January 27, 2020

NEPCO
P.O. Box 714
Monument, CO 80132-0714

Reference: Monument Academy Site Development Plan

ENLARGED SCHOOL SITE DEVELOPMENT PLAN

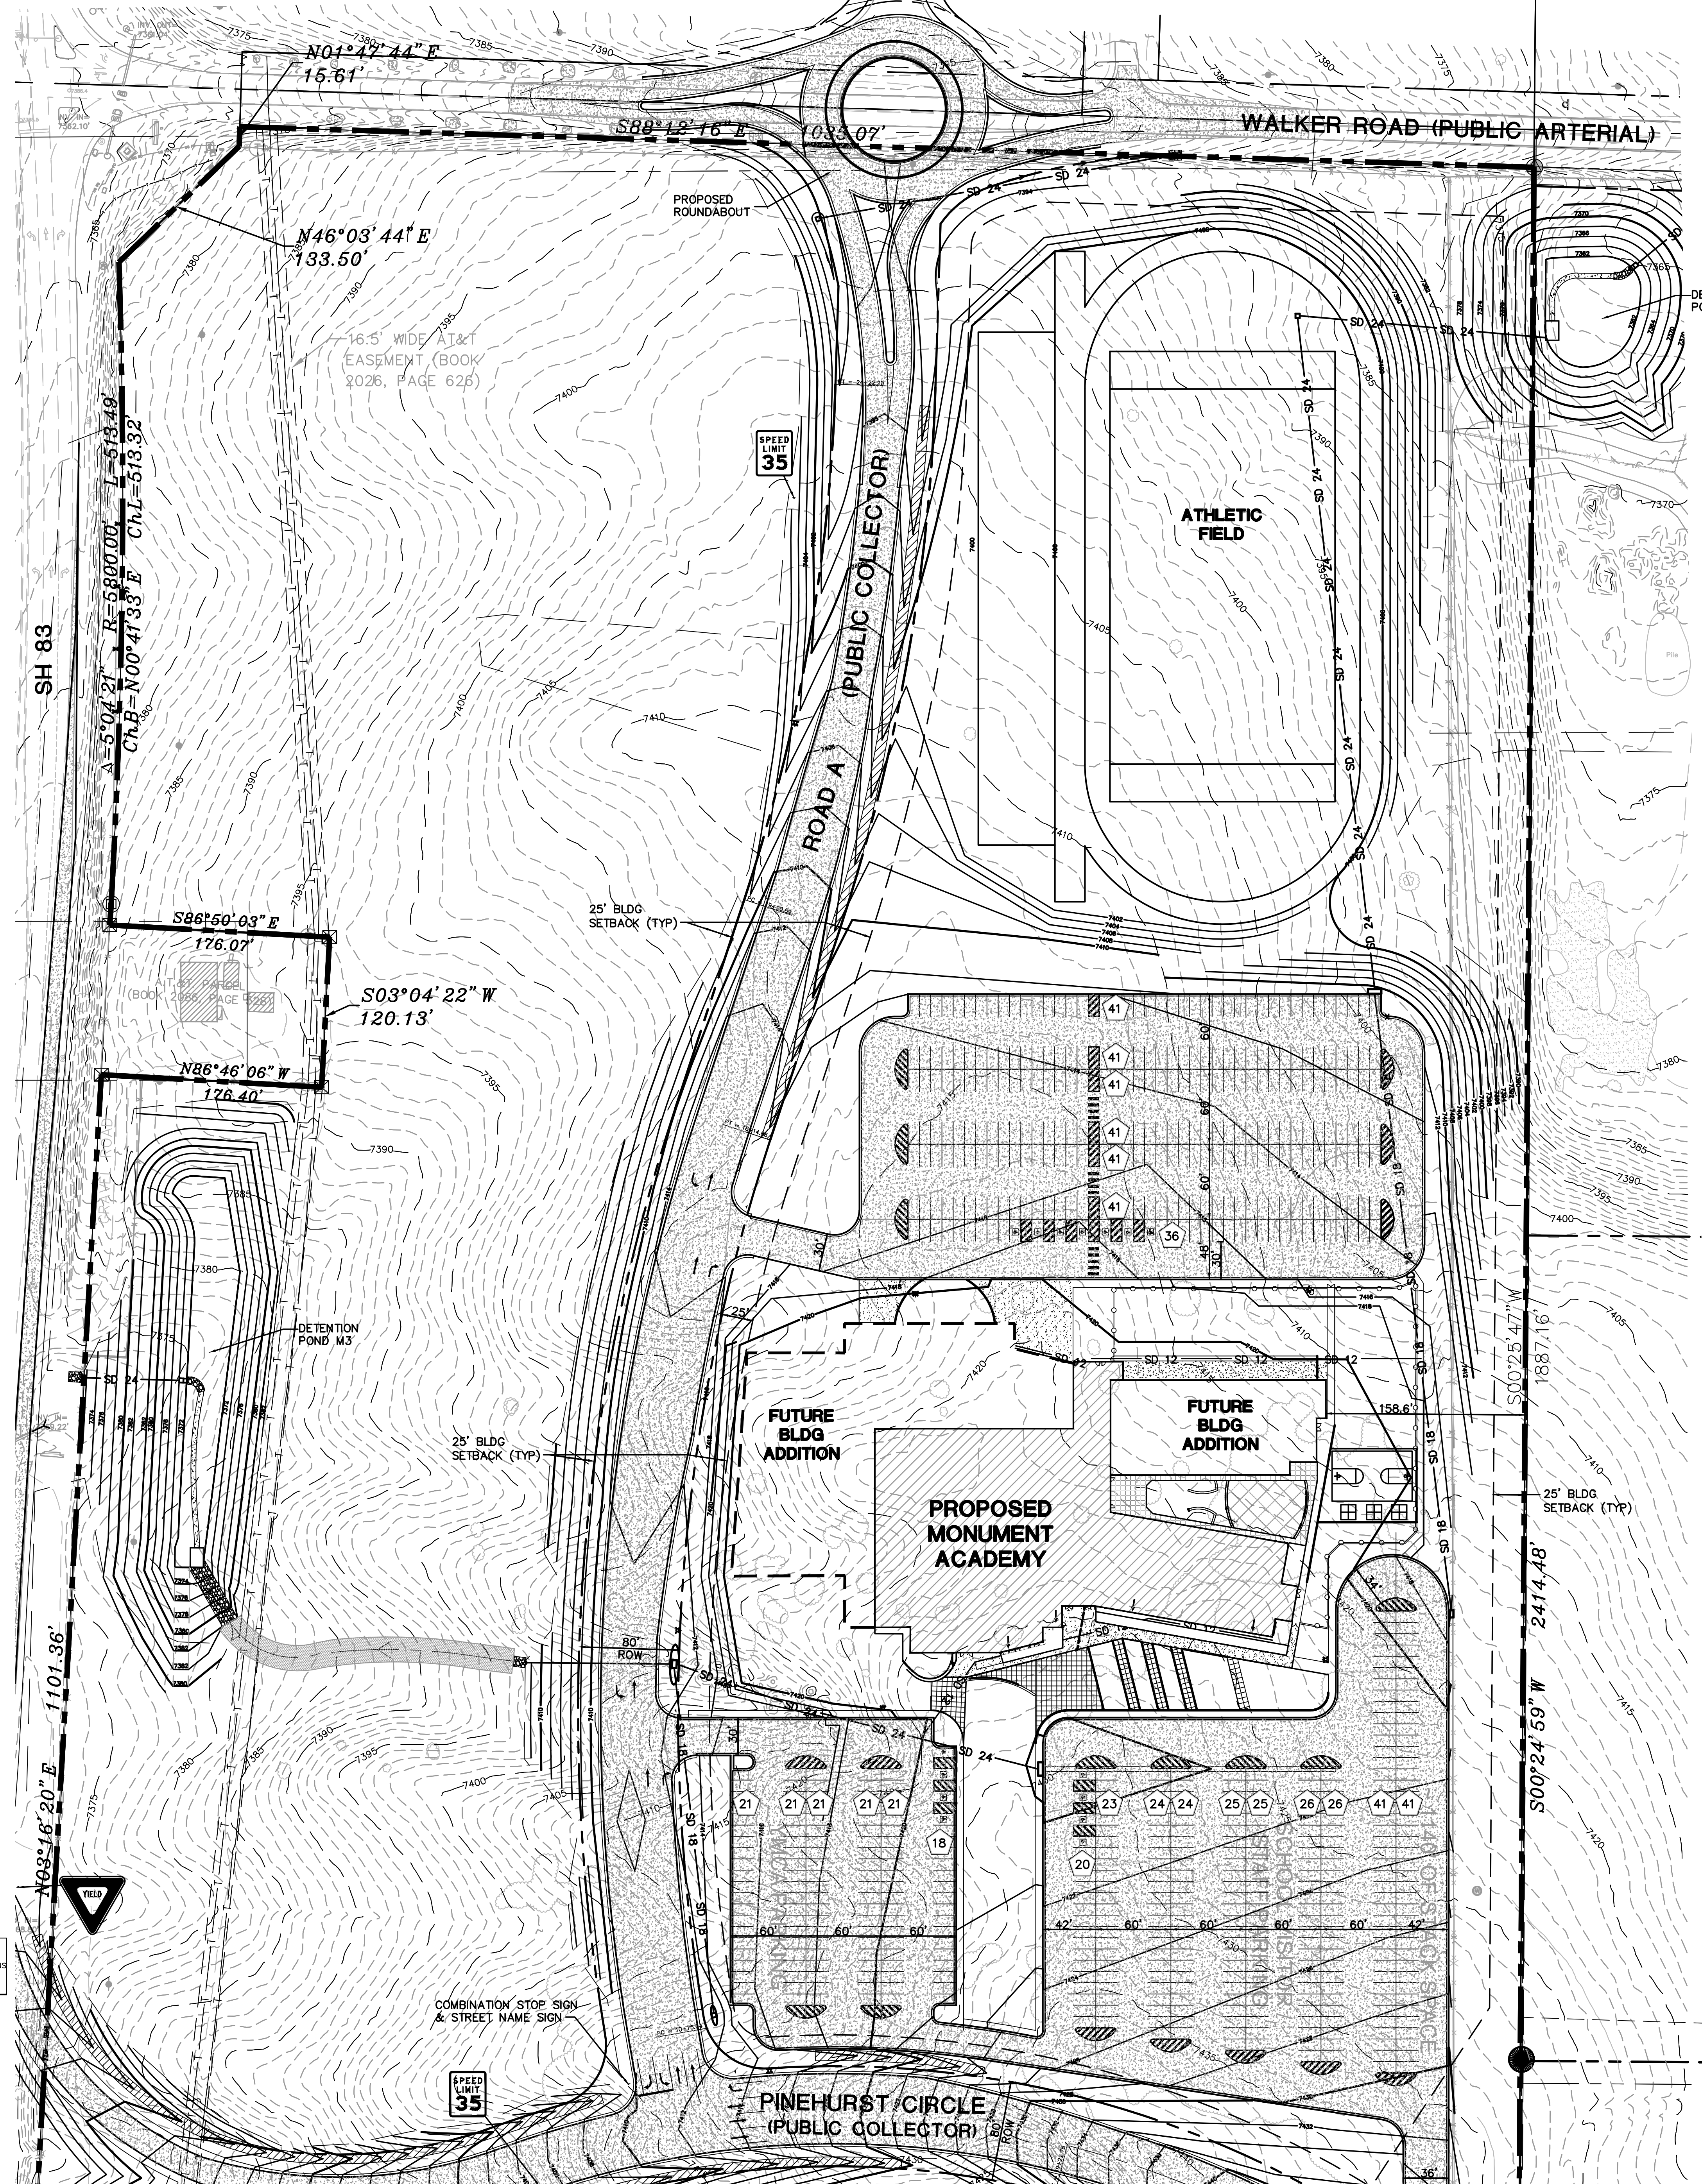
- b. We note, and agree with the developer, that since only half the lot appears to be involved in the school development, this application is limited to the Site Development Plan (SDP) for the school site, and any future development will need to go through the standard County Planning review process. We therefore expect that nothing contained in this application will be relied upon or used for the future development, to include the fact of approval of any document contained in this SDP. **See, for instance, the Parking Spaces table on the Site Development Plan for “future health club and pool parking.” Approval of this SDP, therefore, does not approve these parking spaces.**

- d. Landscaping waiver requests in the Letter of Intent. We recommend that you look closely at these requests. It seems to us that concerns about snow plowing and snow stacking are reasonable considering our climate. **However, waivers based on non-relevant concerns such as the “nature of the site use”, “no immediate plans for development of the adjoining property”, or “adequately meets the functional needs of the school” may carry less weight than the purpose for the landscaping plans, i.e., to provide uniform standards; decrease the scale of parking lots; provide shade; reduce heat, glare, and noise; separate circulation systems; soften and reduce the mass of buildings; screen and buffer lower intensity uses from higher intensity uses; protect residential privacy; and to create an overall pleasant and attractive surrounding. See LDC 6.2.2.(A)(1). In addition, waivers based on the developer’s standard that their alternative landscaping plan “provides appropriate aesthetic landscaping” or “an appropriate program of landscape plantings” should be a non-starter. The relevant Land Development Code section was designed to serve the purposes mentioned above. To allow a developer to substitute his/her standard of “appropriateness” may set an inconsistent and wildly fluctuating precedent for the future. Finally, we also note that the argument that Monument Academy has limited resources is disingenuous -- we all have limited resources. If one is going to build and run a school, many economic decisions will have to be made, and one of them is complying with community standards. Perhaps the administrators’ offices can be furnished in a lesser grade of tile or style of**
